DECISION DELEGATED TO DEVELOPMENT MANAGER

Application No: H06-0189-20 **Applicant:** C Plumb
Proposal: Conversion of barn into pair of semi-detached dwellings
Location: Granite House Chapelgate Gedney
Terminal Date: 30th October 2020

Proposed West Elevation
Scale 1:100

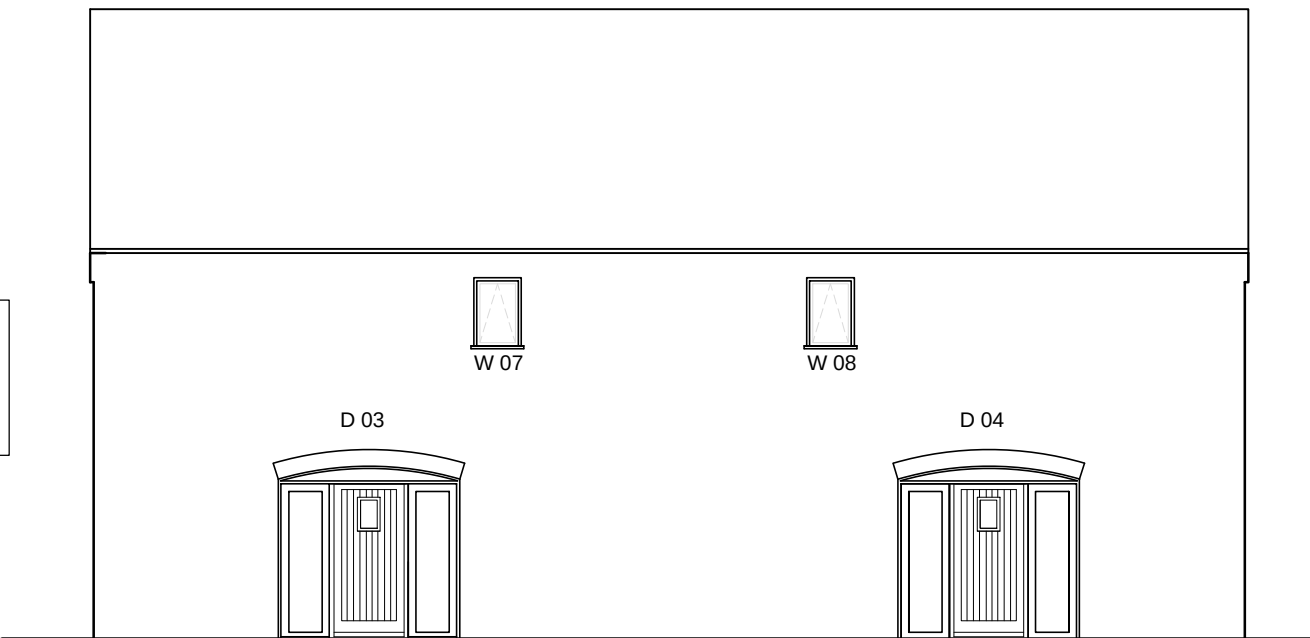
The western elevation includes patio type doors serving a kitchen/lounge at ground floor level and bathroom windows at first floor level. No 5 Whitacre gardens has a number of windows facing east, including kitchen/dining, bedroom and bathroom windows. The first floor windows would be obscure glazed and there is an existing fence on the common boundary, plus a row of Poplar trees. Field Bungalow is located further to the east and would be separated by another building. It is considered that the amenity of neighbouring residents would not be materially harmed in terms of overlooking, lack of privacy, overshadowing or overbearing effect.

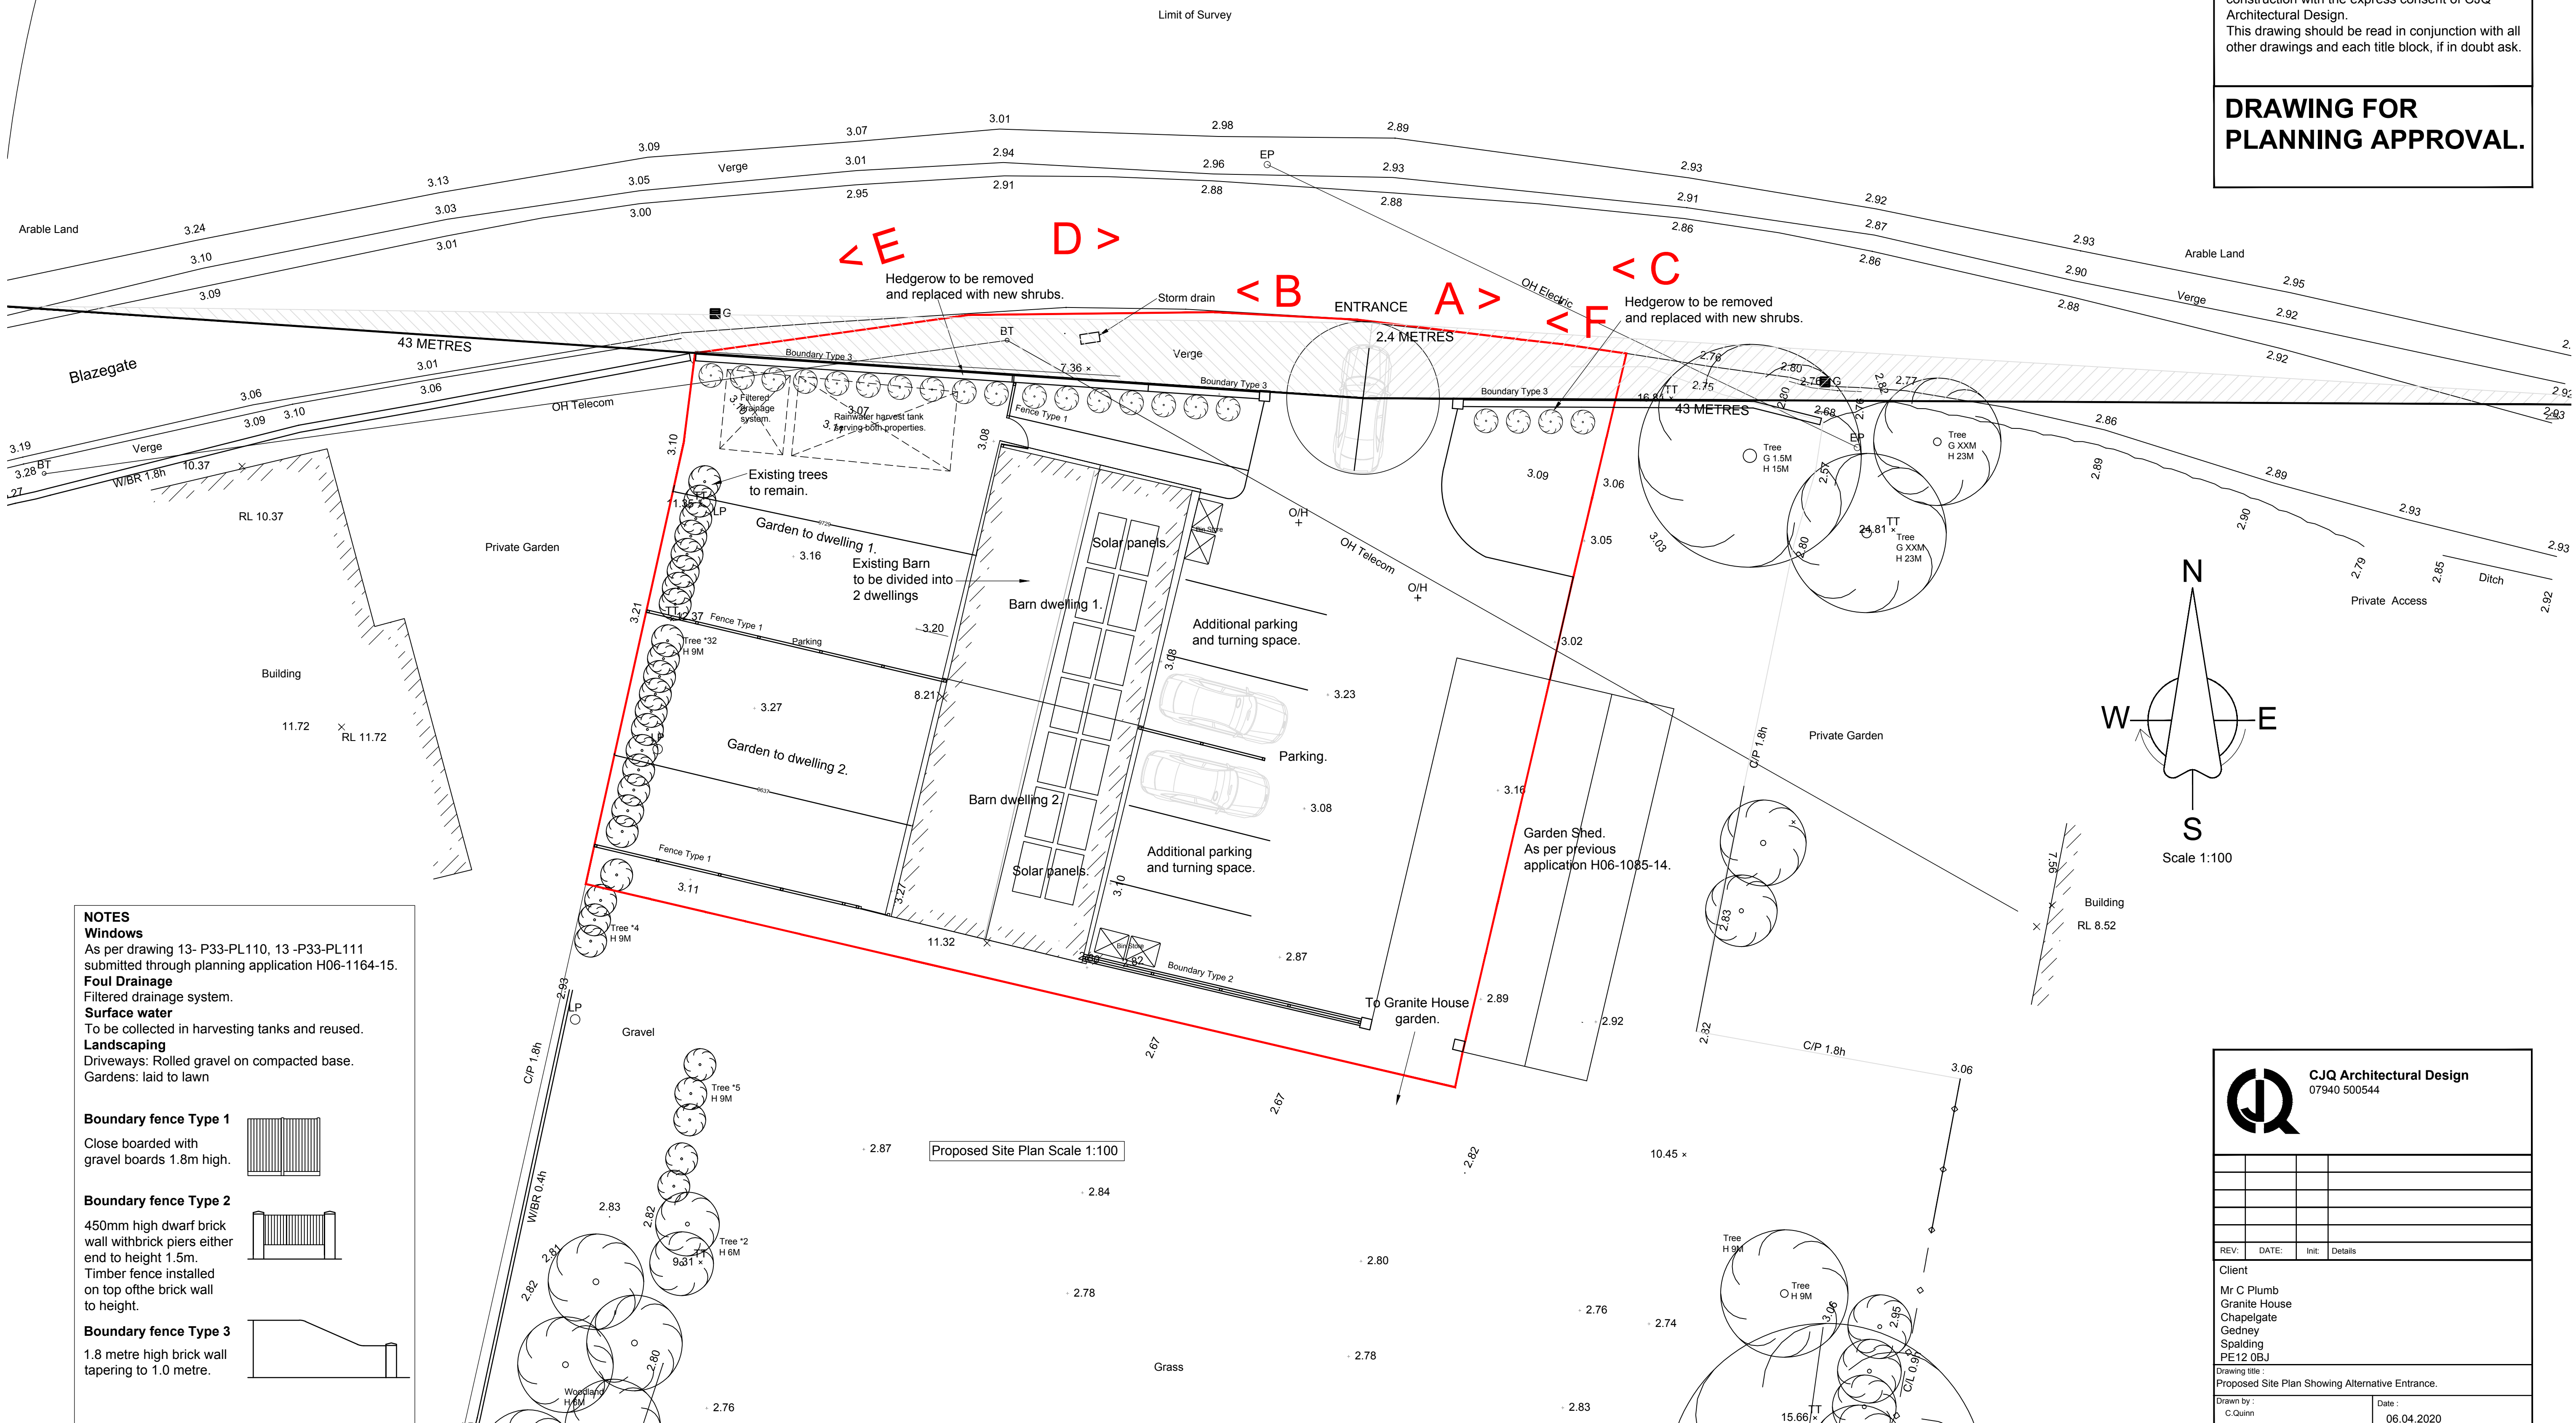
potentially be noisy. The entrance driveway has now been sited further to the east away from the boundary with no. 5 Whiteacre Gardens. The westernmost area is now garden. It is considered that the amenity of nearby residents would not be materially harmed in terms of noise and disturbance, etc.

Concerning the disposal of waste, the bin stores have been positioned on the eastern side of the building away from neighbouring property.

Each dwelling would have two parking spaces. Following concerns raised about visibility the access to the site has been re-positioned further east. LCC Highways have raised no objections to the amended proposal, subject to conditions.
